RE: P247 Multi-family Development Fishers Canyon: Thompson Thrift - City of Fountain Review Comments

The City of Fountain has reviewed the submittal package posted on the El Paso County EDARP web site. Our comments pertain to the Letter of Intent and the Traffic Impact Study, as follows:

FIGURE 4
 VENETUCCI THOMPSON THRIFT
 EL PASO COUNTY, COLORADO
 2025 BACKGROUND TRAFFIC VOLUMES

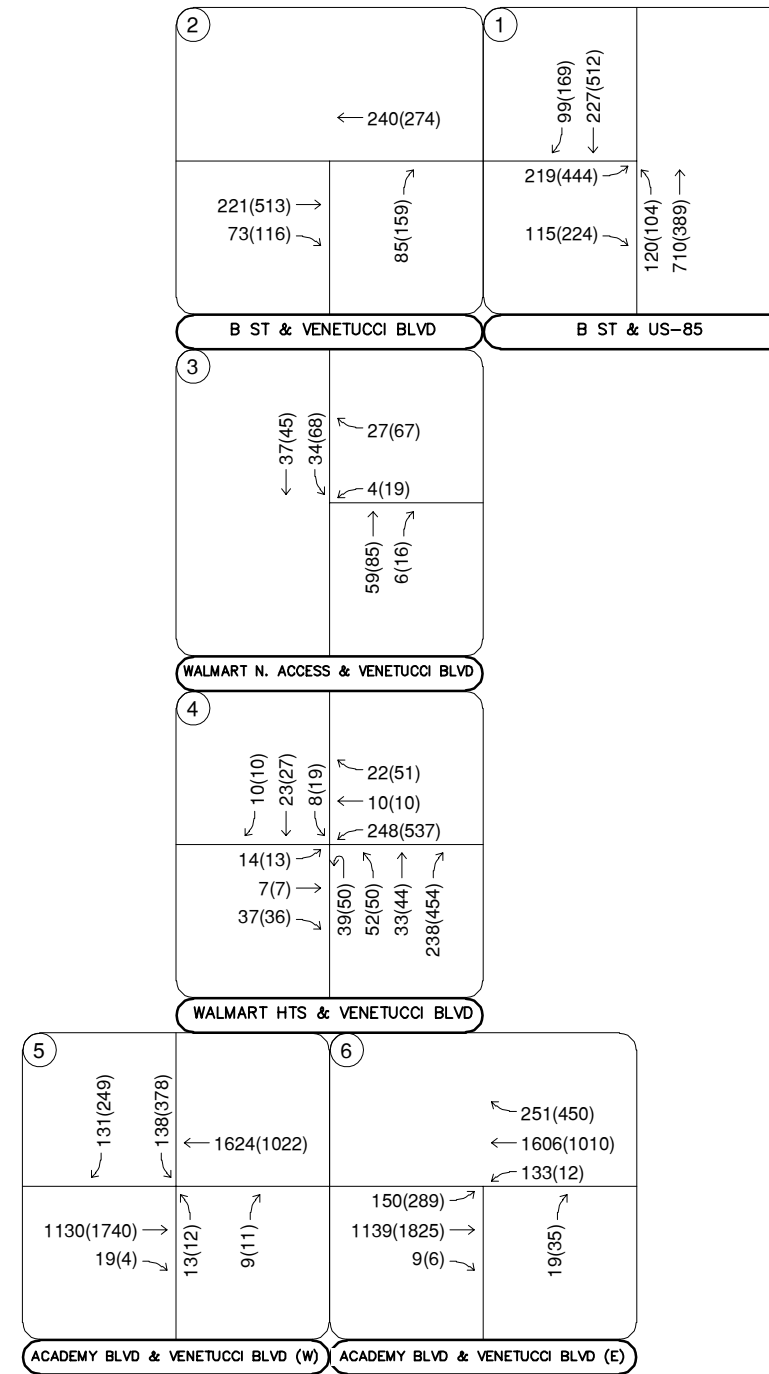
The Traffic Impact Study (TIS) must align with the Max Green Transportation Engineers' South Academy Highlands Traffic Study and Wilson and Company's detailed study of the Venetucci Boulevard and B Street Intersection. Appropriate growth factors for different roadway classifications must be used to forecast traffic volumes in 2023, 2025, and 2045. The South Academy Highland TIS should be used to verify trip generation, including both inbound and outbound trips. Lastly, the 4% project traffic contribution on B Street and Venetucci must be reevaluated, as Figure 4 of the TIS indicates a PM peak Volume of 116 instead of 5.

Acknowledged. Updated TIS provided to El Paso County.
